RE: M-51 Industrial– Response to City Comments

Please refer to our responses below which address all review comments received from the City of Marysville on September 1, 2023, regarding the M-51 Industrial submittal package. You will find the markup comments listed in the order that they were written followed by our response in *italics*.

LEGEND

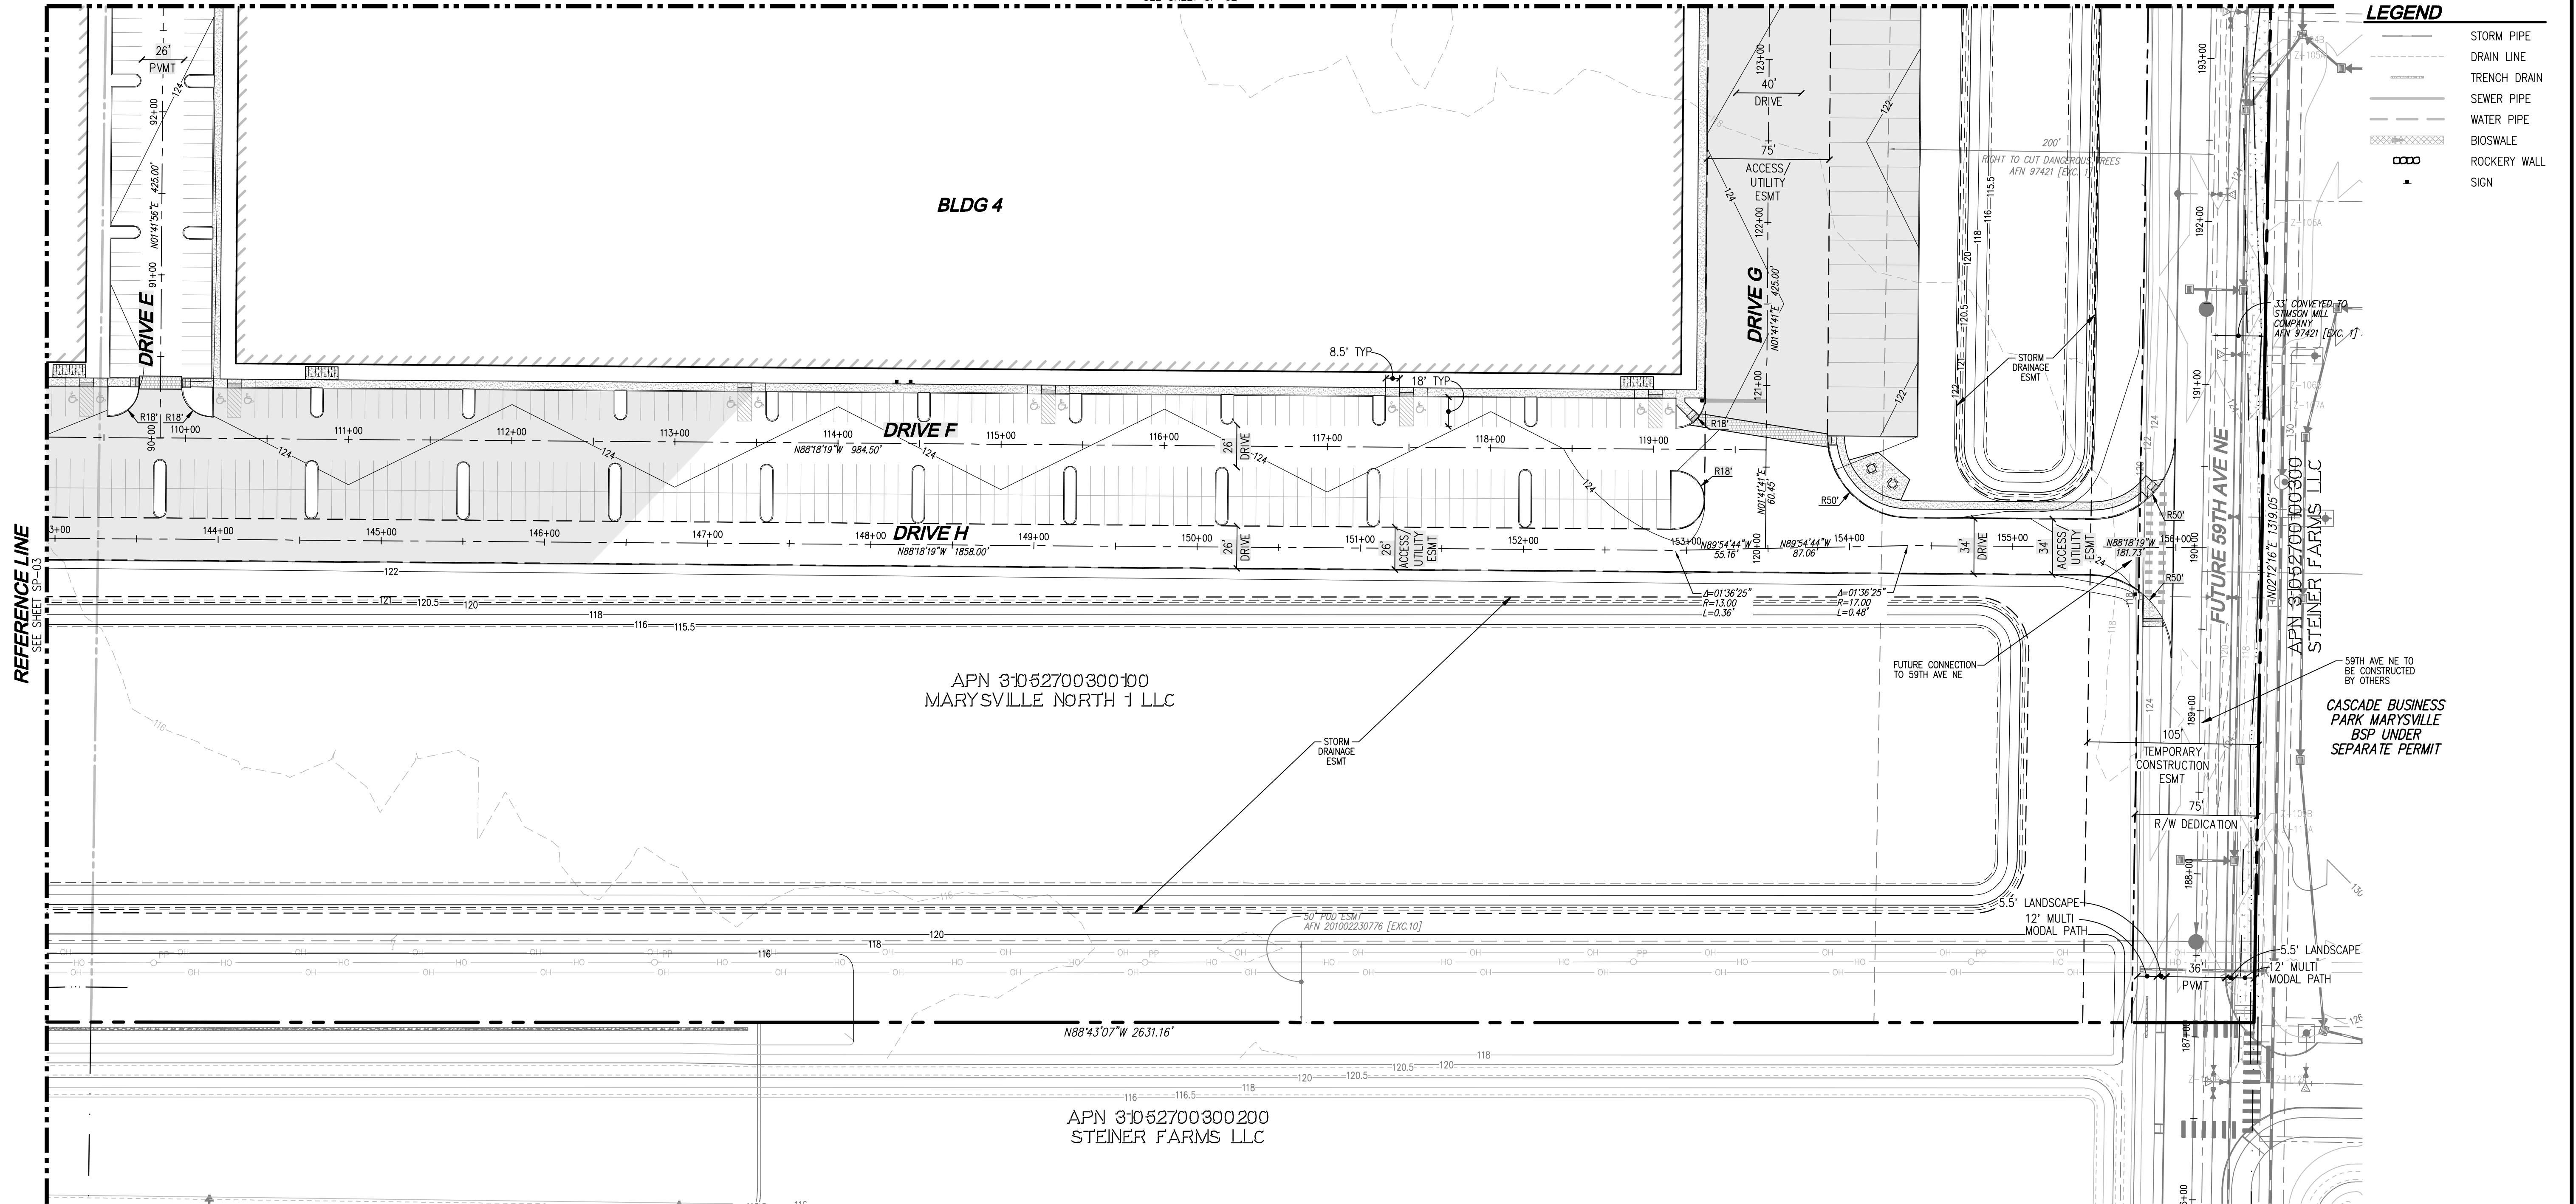
2. See attached comments from Snohomish County PUD related to access to the existing power lines.
Response: Noted.
- Site Plan Edits:
3. Pedestrian connections shall be provided from 51st Avenue NE and 59th Avenue NE and the building entrances. Pedestrian pathways that traverse a parking area or drive-aisle shall be constructed with decorative concrete.

Response: Revised site plan with the pedestrian access from 51st Ave NE and 59th Ave NE as noted.
 4. Parking areas shall include a landscape island every 10 stalls. The landscape islands shall be a minimum of 5' in width and 120 SF in size.

6. The standard parking stalls shall measure 8.5' x 18'.
Response: Revised plan set with above noted dimensions.
 7. Provide off-street parking calculations, including standard ADA, carpool and bicycle demonstrating compliance with the MMC.

Response: Added off-street parking calculations.
 8. Five spaces or five percent of the parking spaces on site, whichever is less, must be reserved for carpool use before 9:00 a.m. on weekdays. More spaces may be reserved, but they are not required.

Response: Revised site plan with carpool parking and above note.
 9. Carpool spaces will be those closest to the building entrance or elevator, but not closer than the spaces for disabled parking and those signed for exclusive customer use.

11. Bicycle parking shall be provided at a rate of 5% of the number of required off-street auto parking spaces. Design and location shall be provided in accordance with MMC 22C.130.060.

12. Provide location of required ADA parking spaces.

13. Provide location of required carpool parking.

14. Provide location of required bicycle parking.

24' DRIVE TYPICAL SECTION

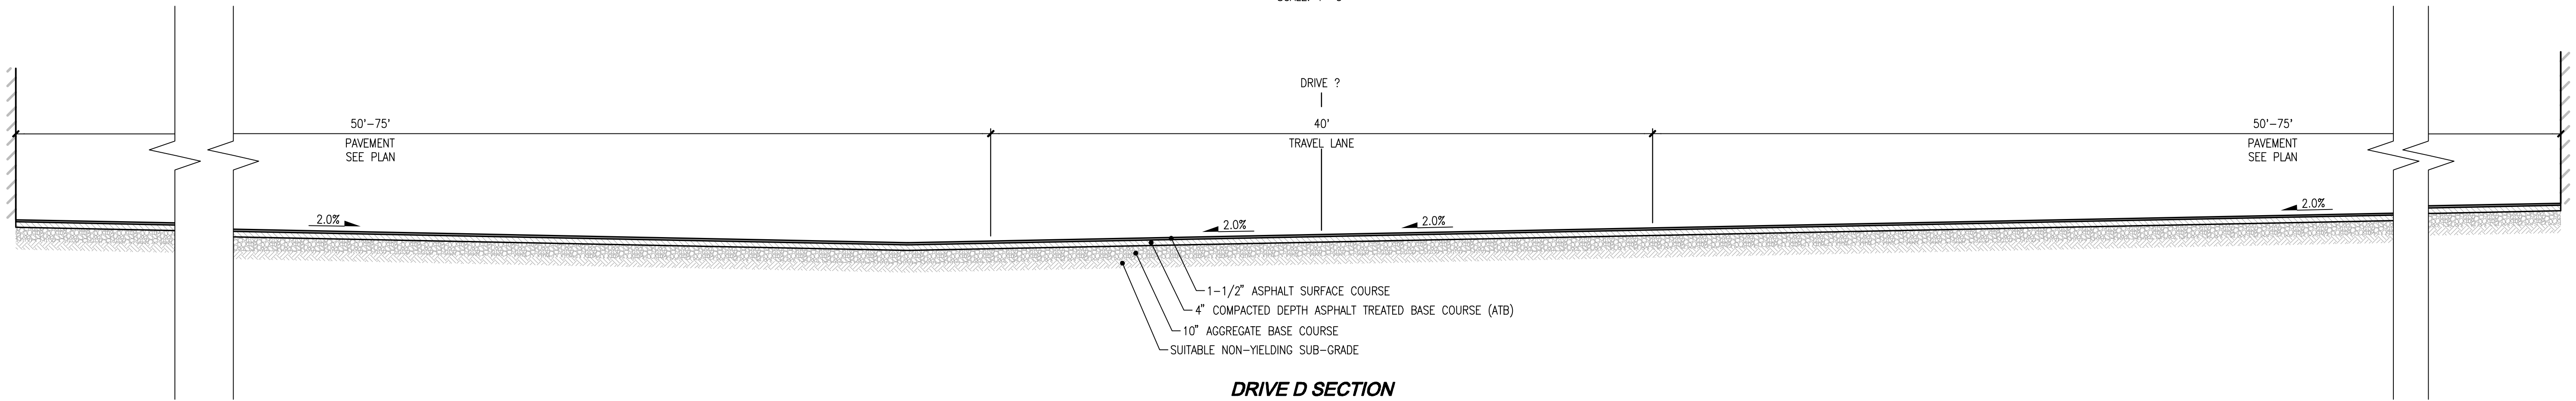
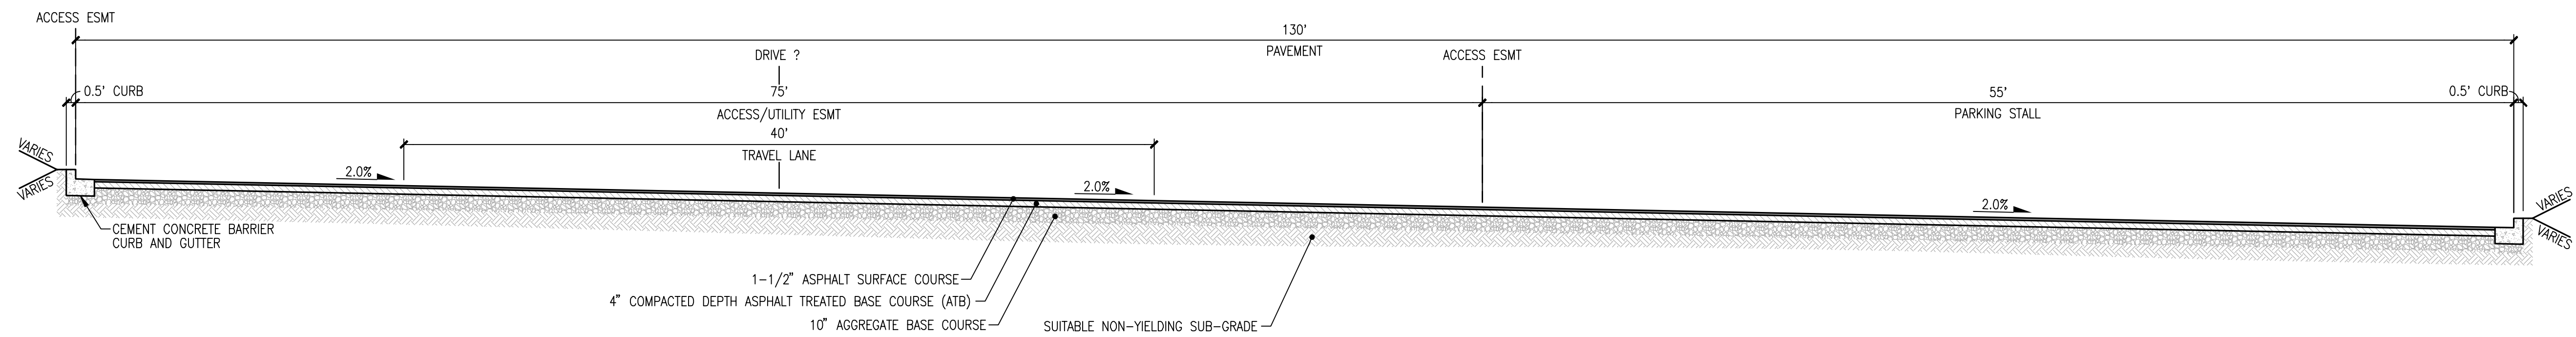
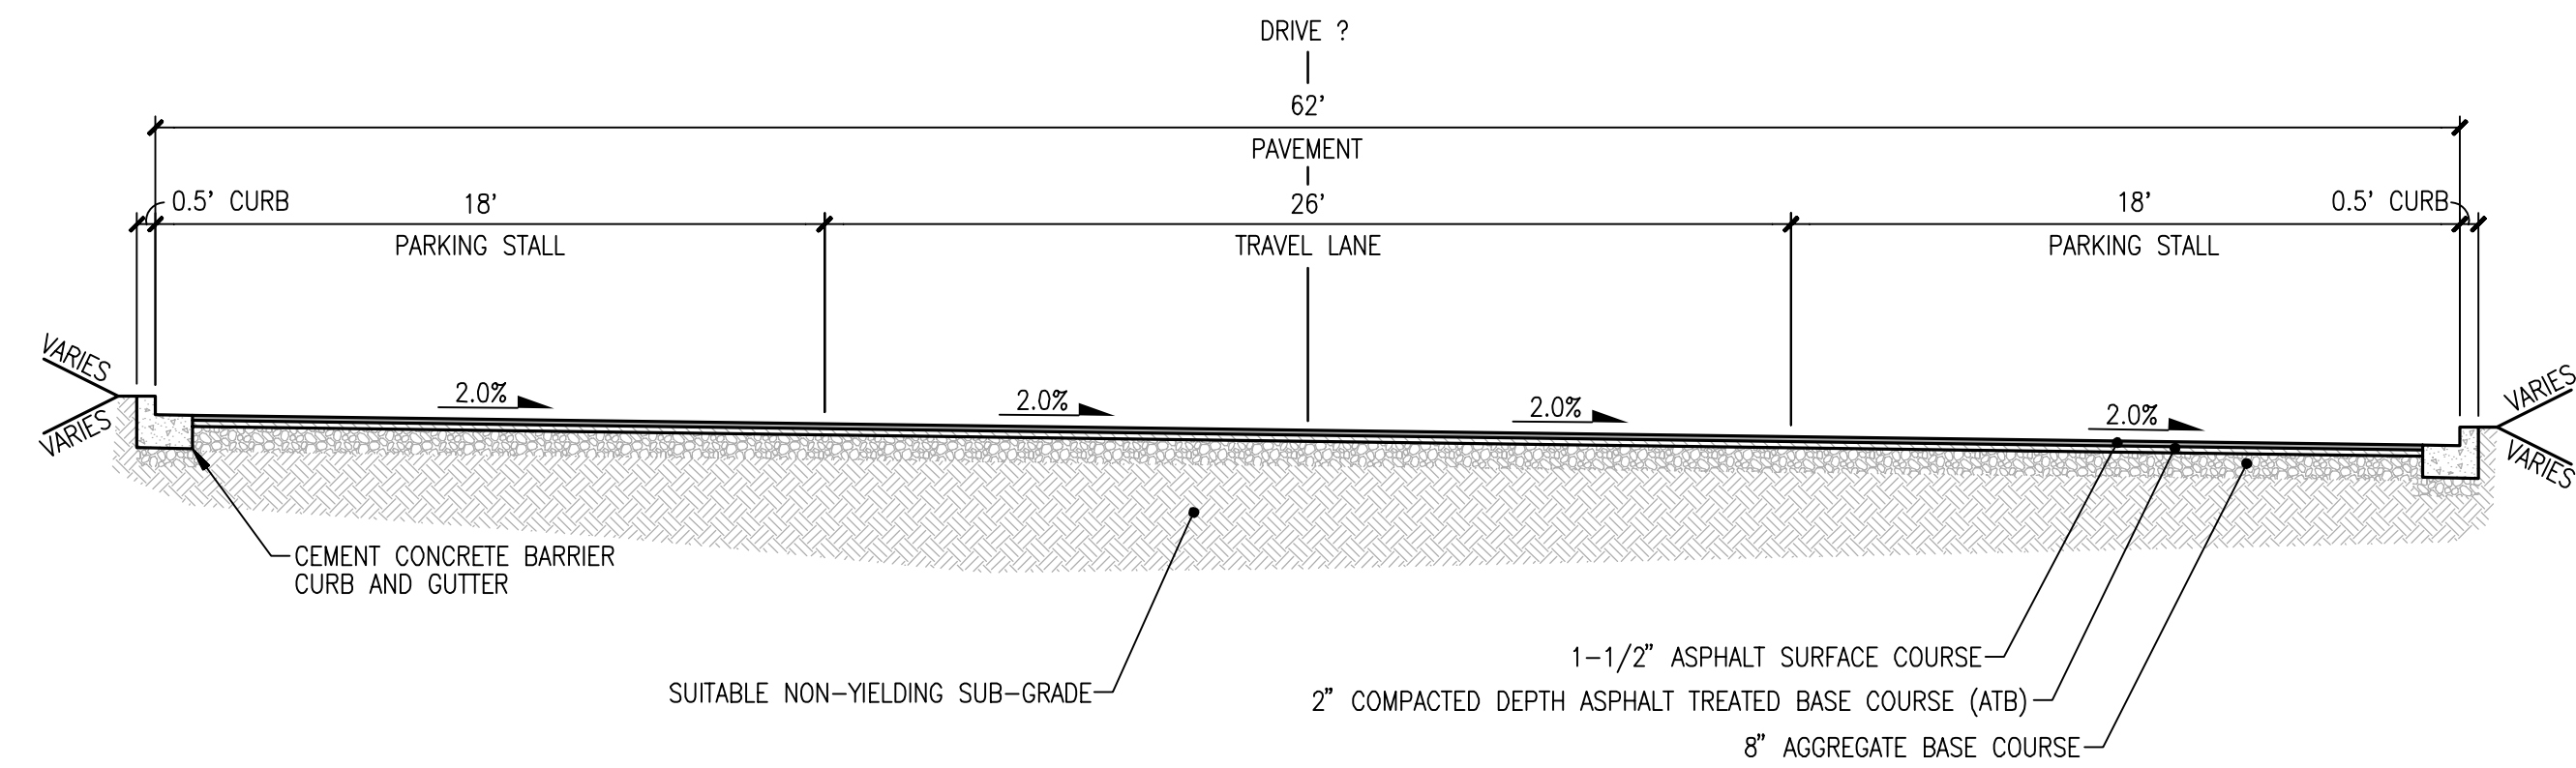
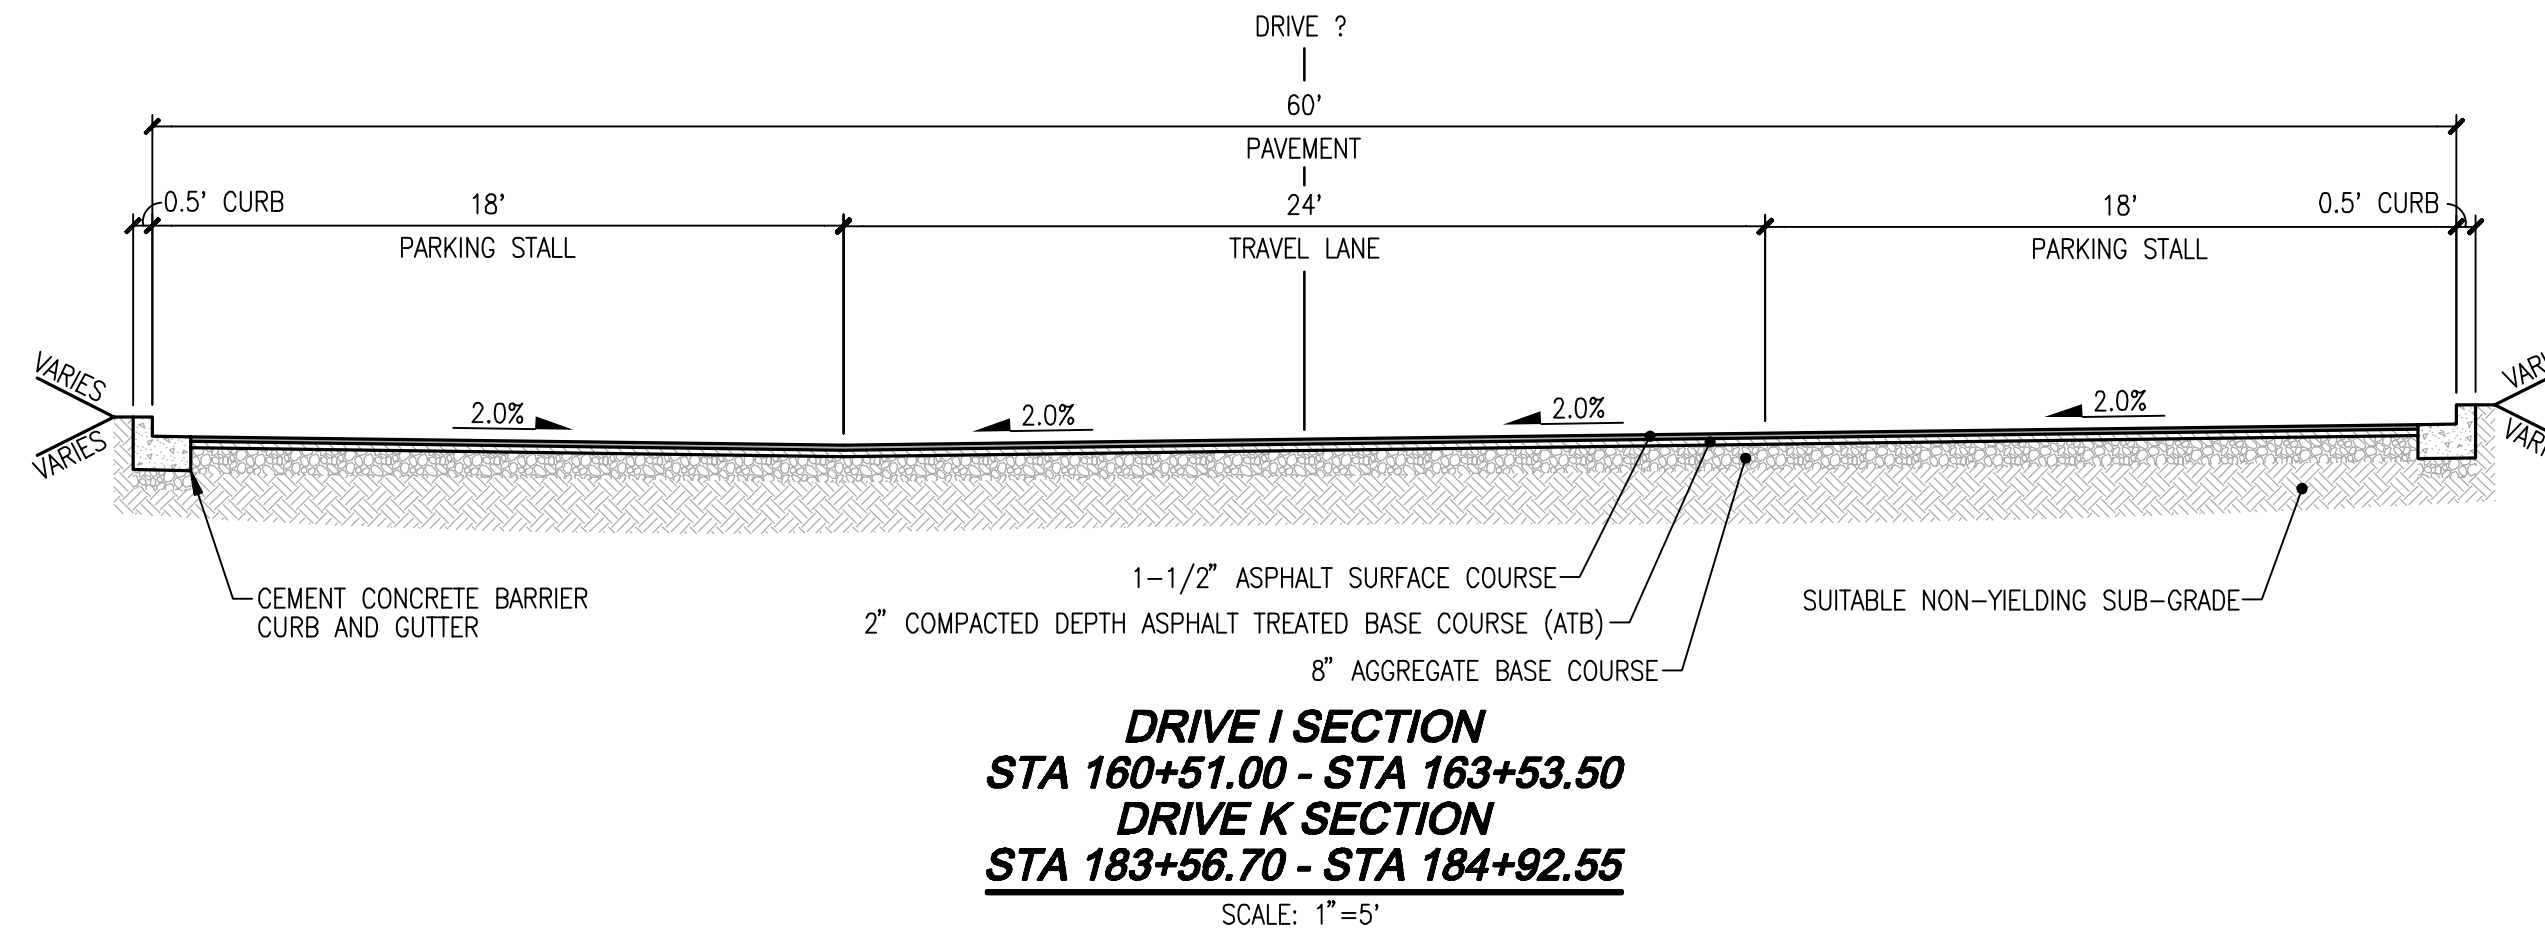
Response: Revised plans as noted.
 5. The site plan states the drive-aisles measure 24' in width, however, they only measure 22' in width.
Response: Added drive-aisles dimensions.
